172 Falmouth St.

Nathan Clifford
School

IV. Proposed Development

VI. Issues for Review of Final Application

| SITE LAYOUT, AND UTILITY PLAN | | |

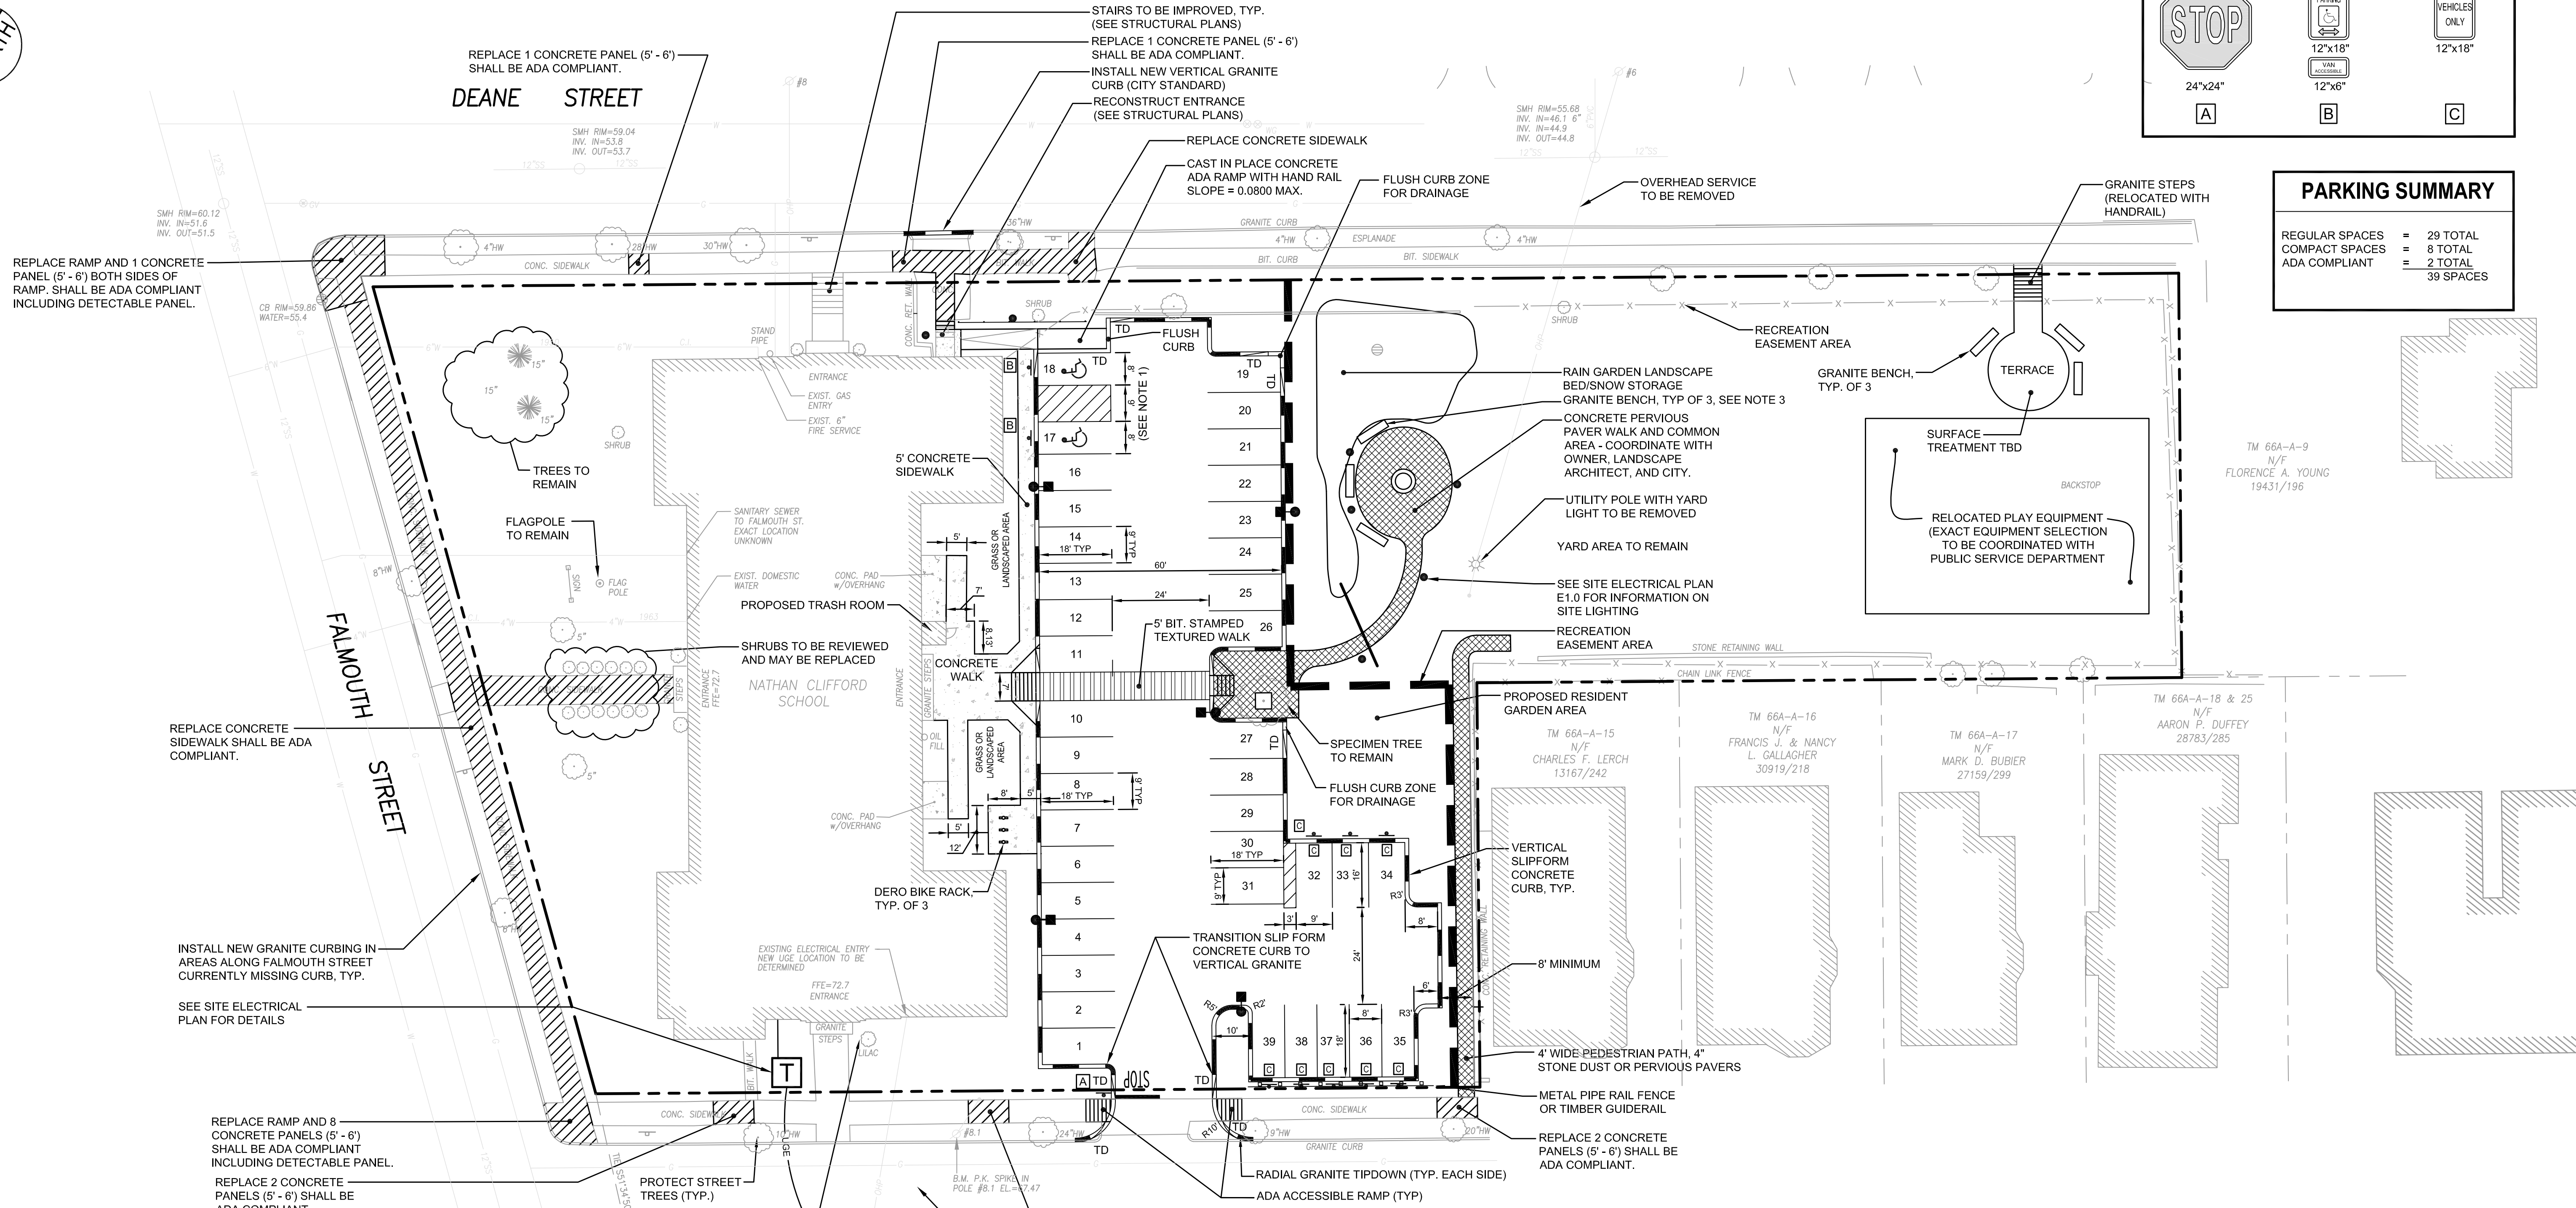
2. Currently the proposed rain gardens do not show an outlet. Can the additional proposed impervious area be kept below 1,000 sf to avoid the need for stormwater treatment?

3. The abutting sidewalk and curbing around the Nathan Clifford School is in need of repair/replacement. In lieu of spot repairs along Falmouth Street, the applicant is requested to replace the concrete sidewalk in its entirety on Falmouth Street including the crosswalk ramps at both Payson and Deane Streets. In addition, there are several sidewalk areas on both Payson and Deane St that are tripping hazards and need repair. City staff can work with the applicant to determine those locations and how best to address those areas needing repair. City staff will also provide guidance as to the correct alignment of the corner crosswalks. Some granite curbing re-alignment will be necessary.

4. As required by code, all overhead utility lines must be feed to the site underground from the street right of way.
5. It would be desirable to eliminate the curb cut and concrete drive apron on Deane St and replace with a walk.

The plans in the packet show (Attachment P4, Sheet 3) the general layout of the parking and landscape features. Board members should note the location of parking, a dumpster, and a pedestrian pathway located abutting the Payson Street neighbor to the south of the subject

property. Staff encourages the applicant to move the dumpster further from the abutting property, and keeping it from having a significant visual impact on any abutting street. Staff has asked the applicant to consider an interior trash room. Regardless of the location of the dumpster, additional landscaping between the parking and the abutting property should be provided. A letter of concern from the abutting neighbor is provided in Attachment 1.
